CITY OF ALBUQUERQUE

September 27, 2019

RE: **Catalonia Subdivision**
Tr 1 & 2, The Trails Unit 3A
Drainage Report Stamp Date: 9/16/19
Grading Plan Stamp Date: 9/16/19
Hydrology File: C09D013

Based on the submittal received on 9/17/19 the above-referenced Drainage Report and Grading Plan cannot be approved until the following are corrected:

CATALONIA
OVERALL GRADING PLAN

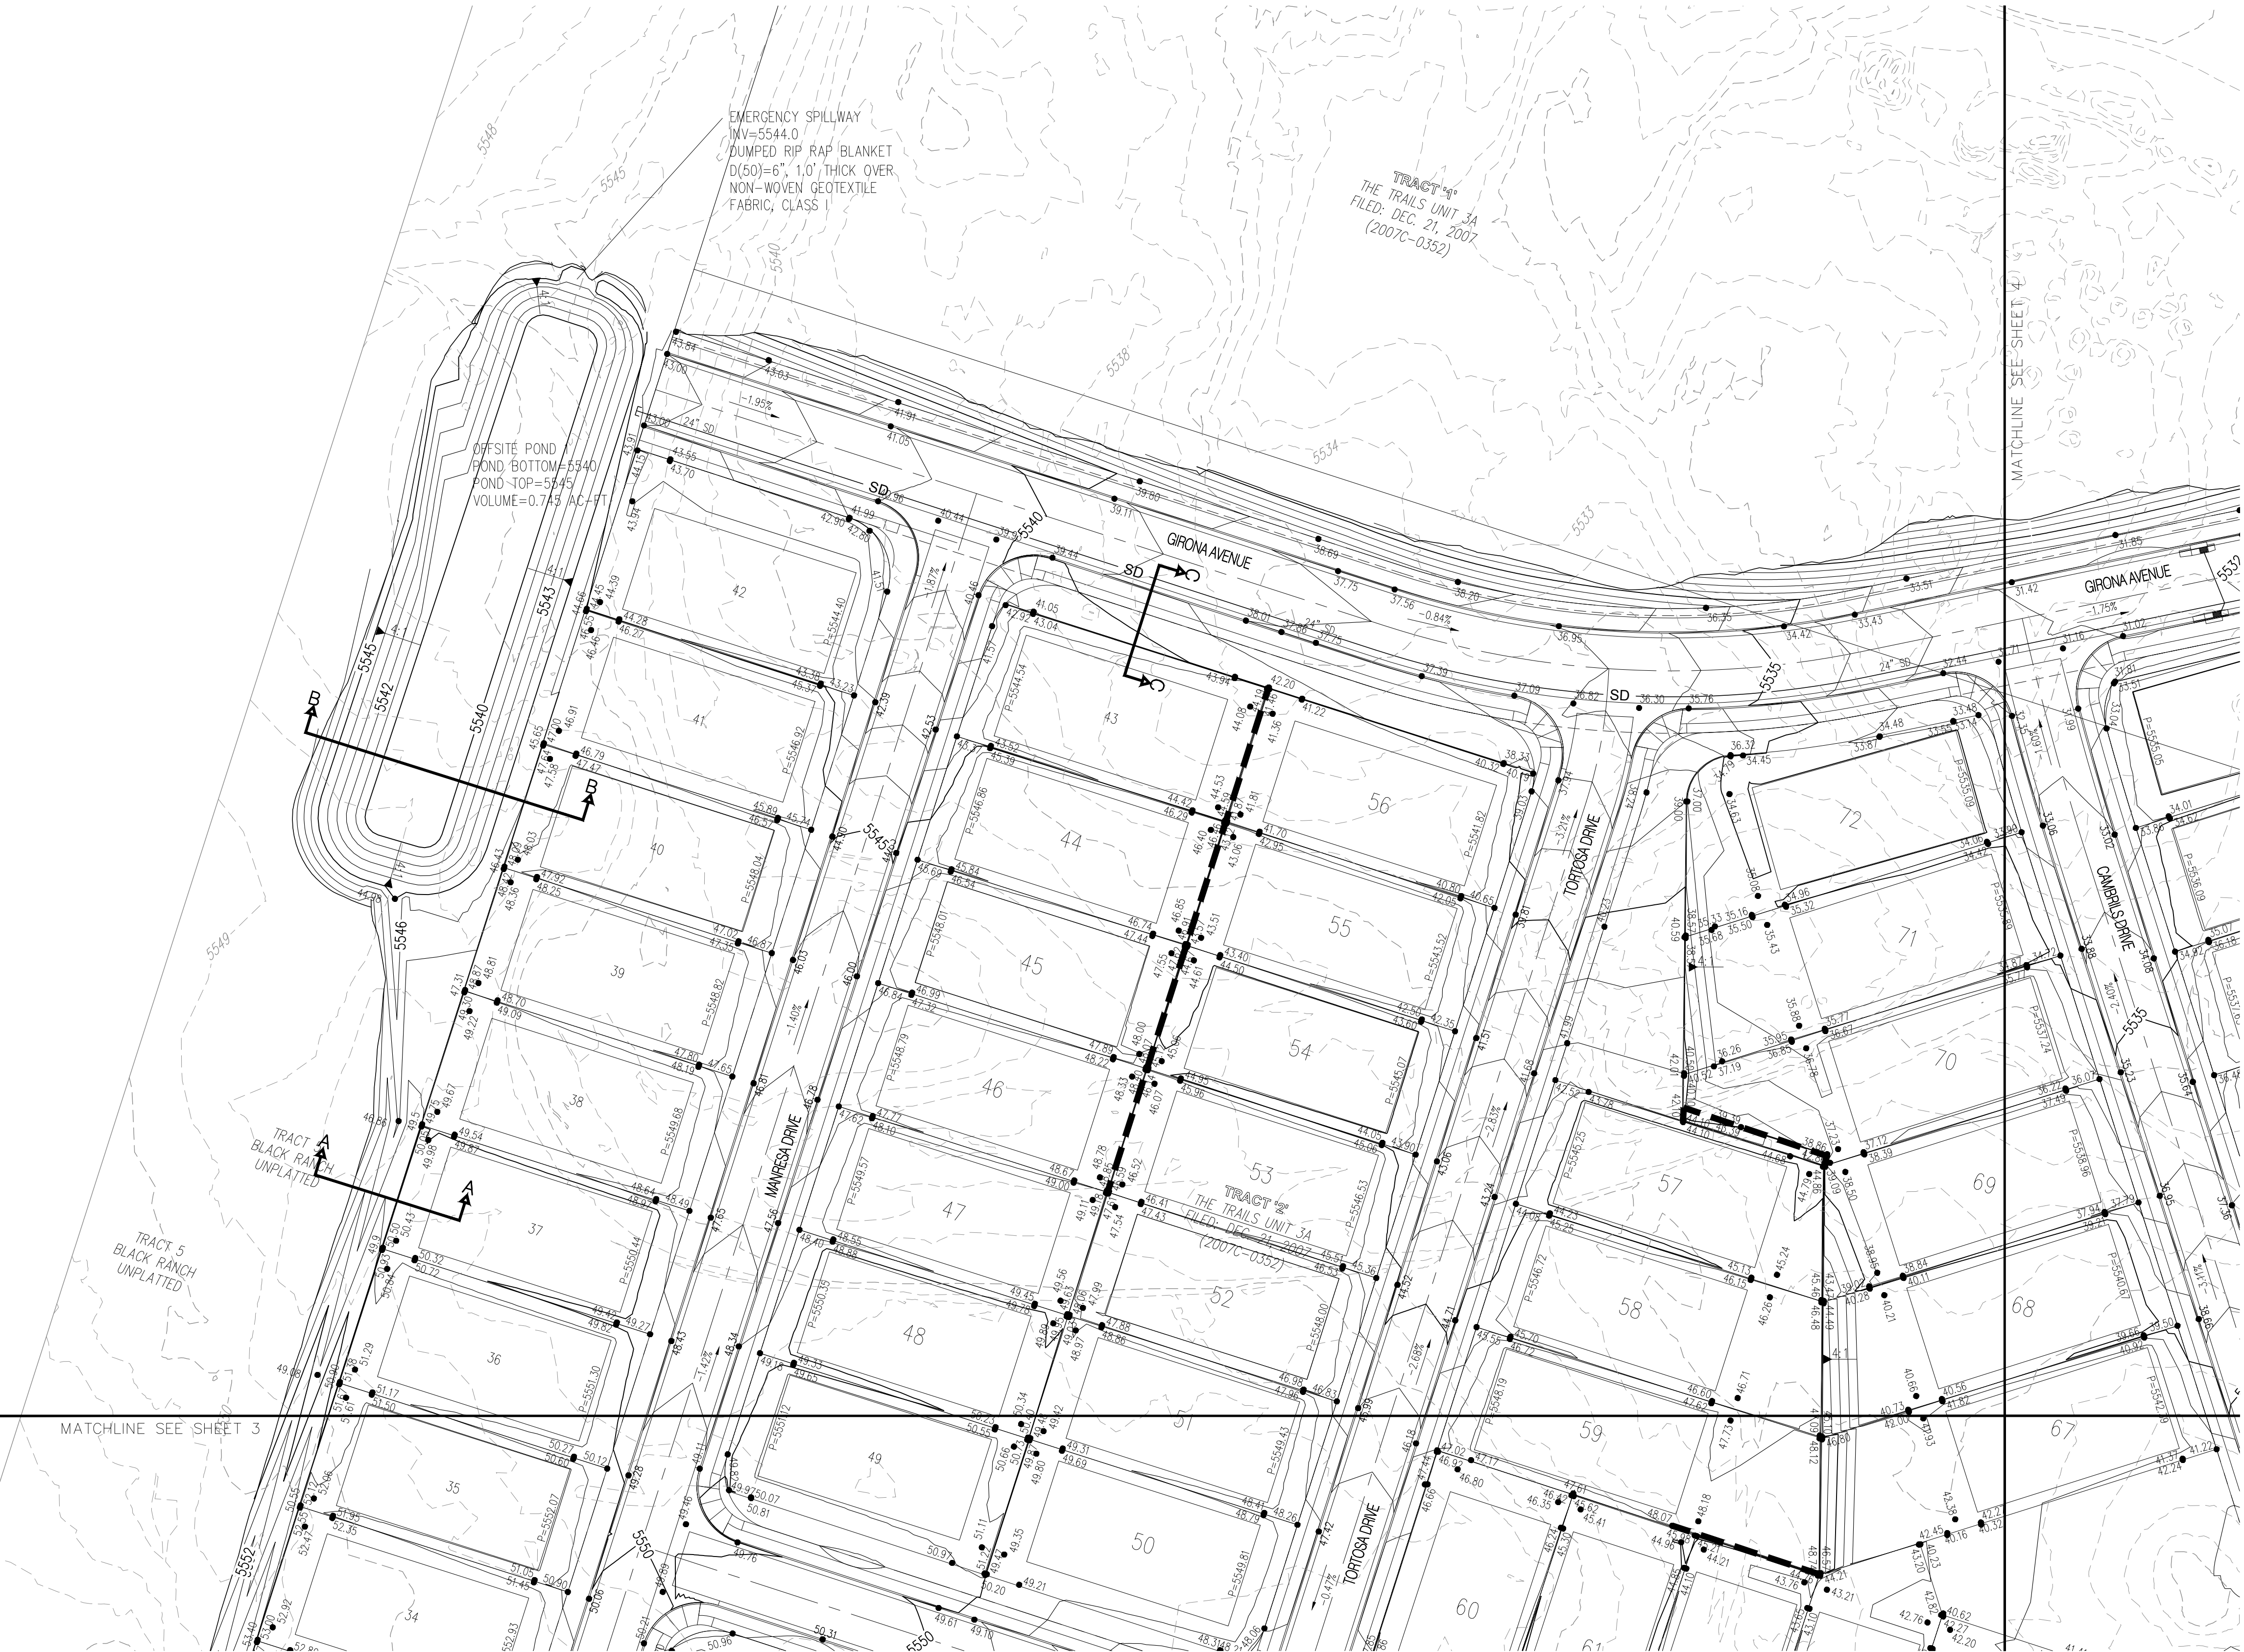
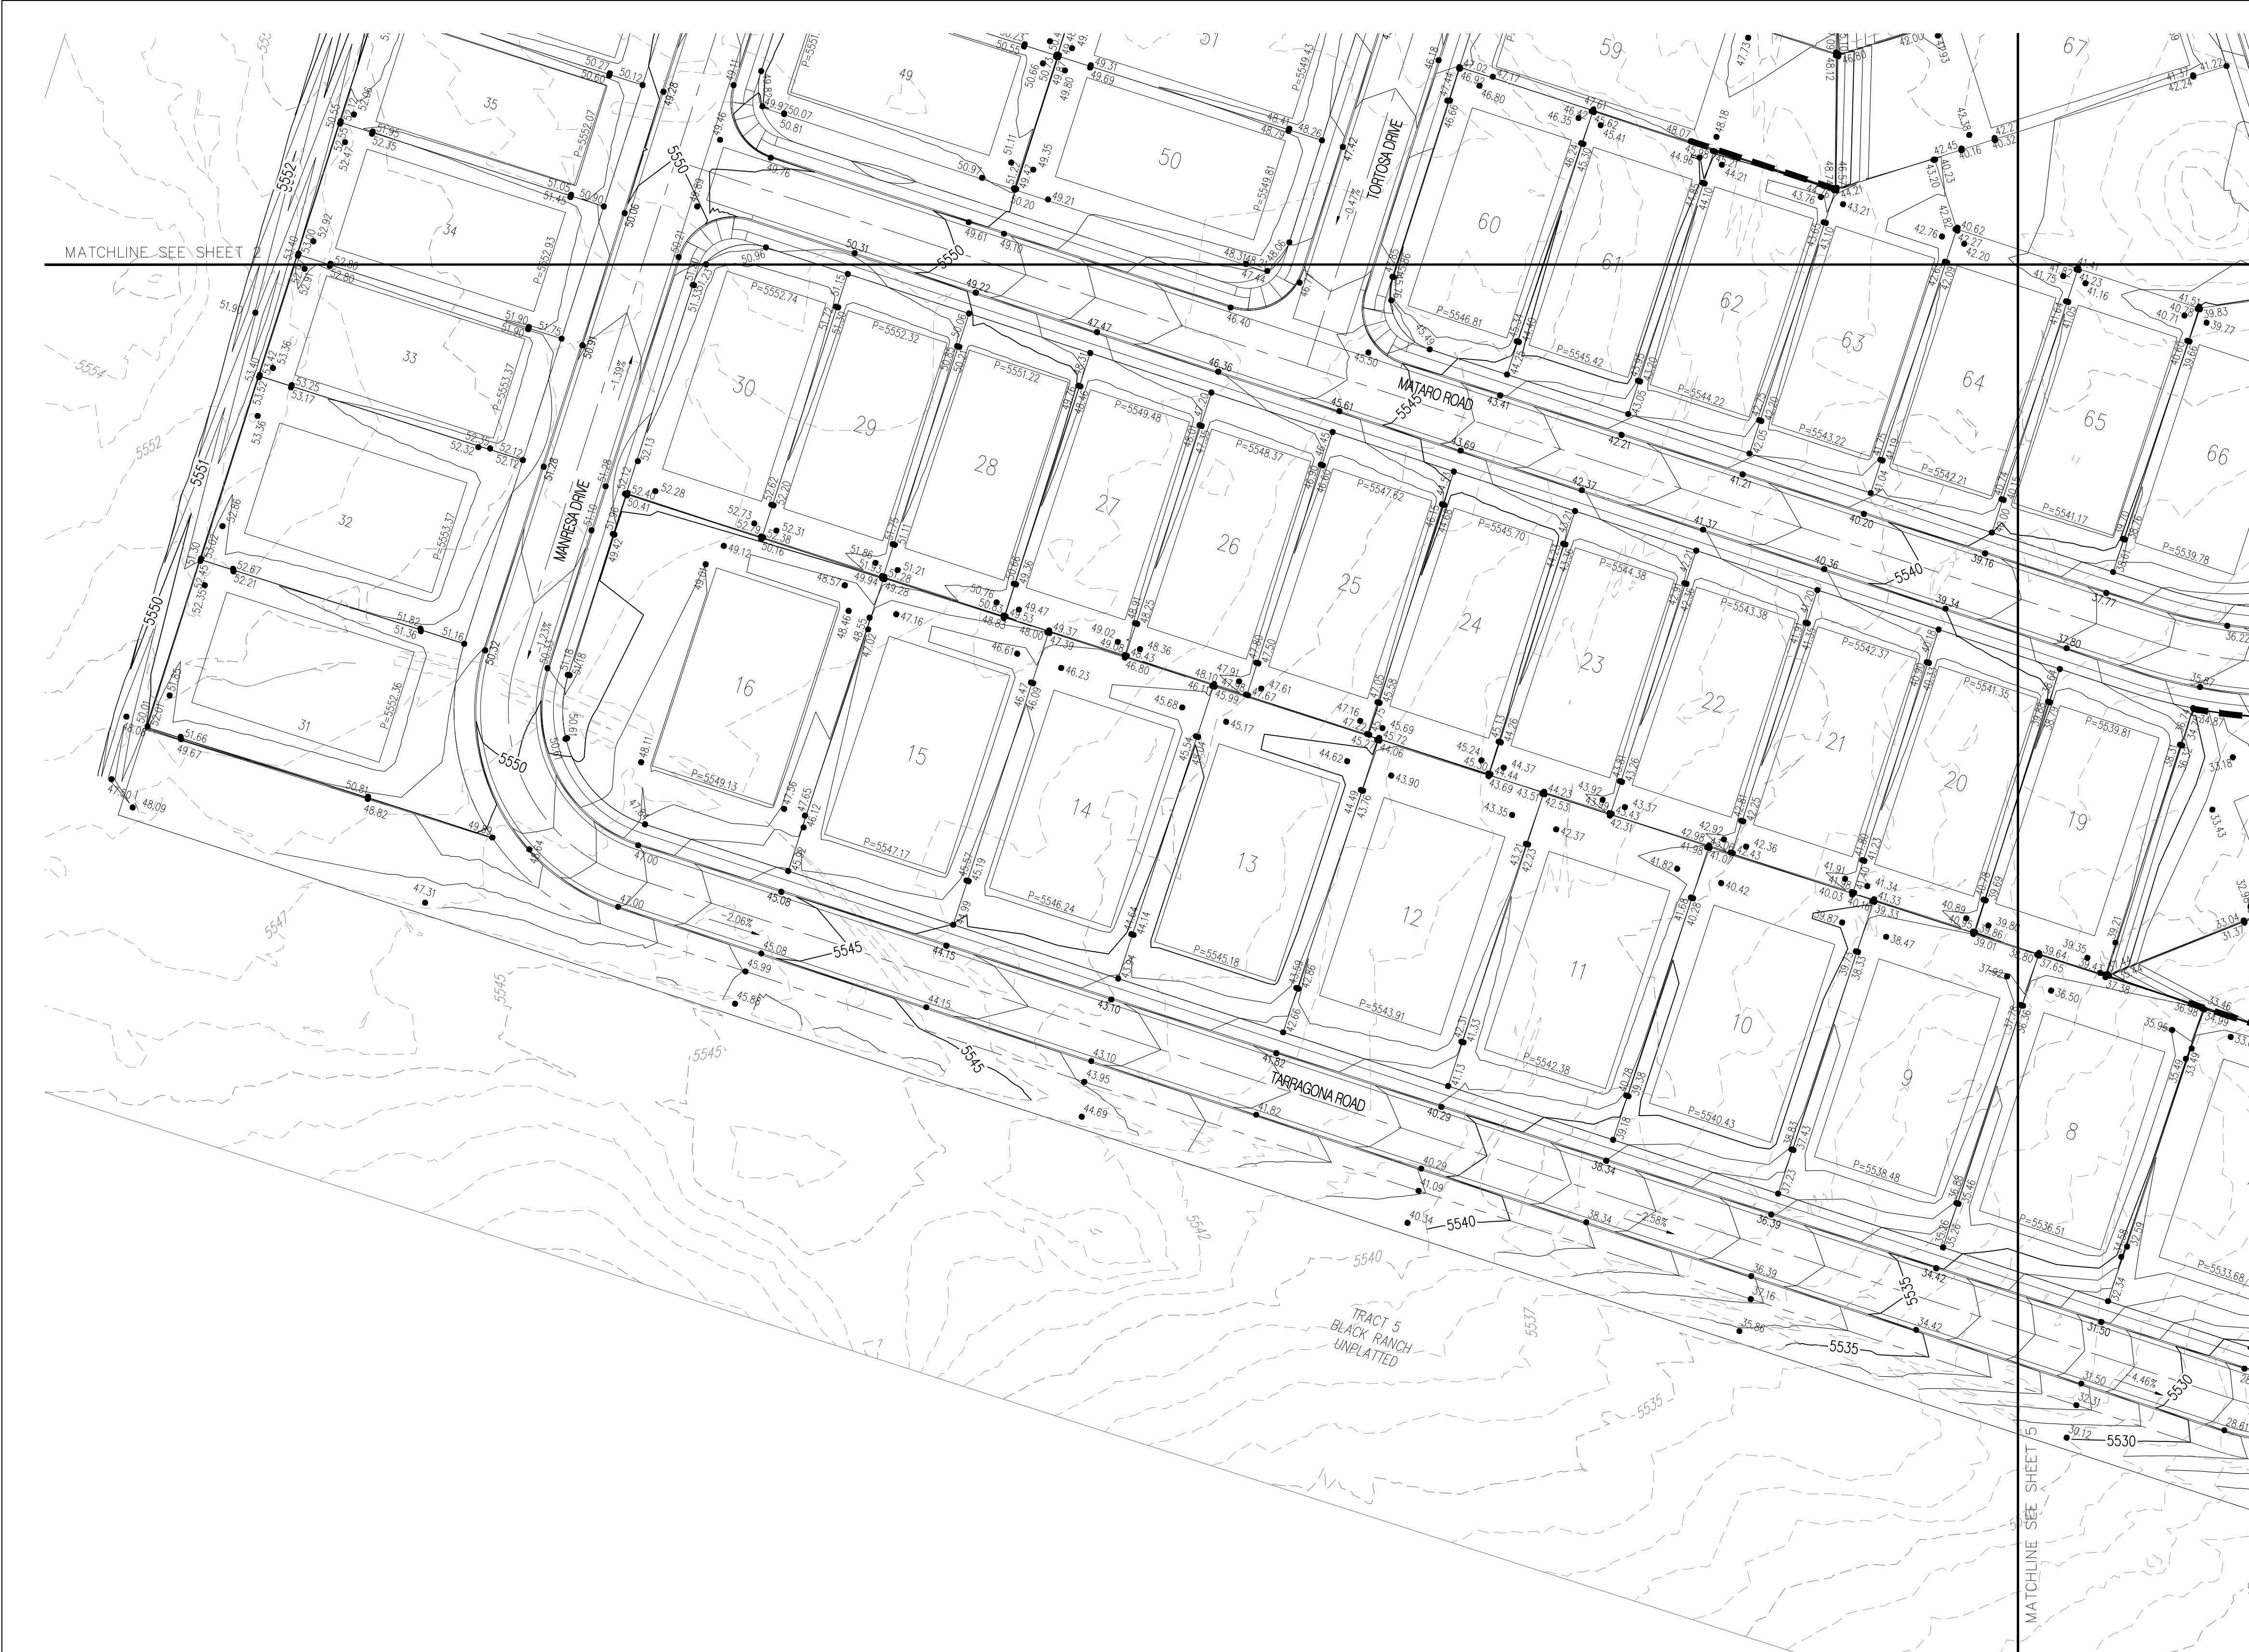
1. Offsite Pond 1.
 - a. Provide written and signed permission from the owner of *Portion of Tract 5 in the W/2 NE/4 NW/4 SEC 17 T11N R2E* for the grading and swale/pond construction on their property.

5. Provide dimensional data on plans (top width, bottom width, depth, etc.) for the spillways and swale.
6. Provide outlet structure detail for Offsite Pond 1 with 12" diameter orifice plate. Provide outlet structure detail for Pond B with 6" diameter orifice plate.
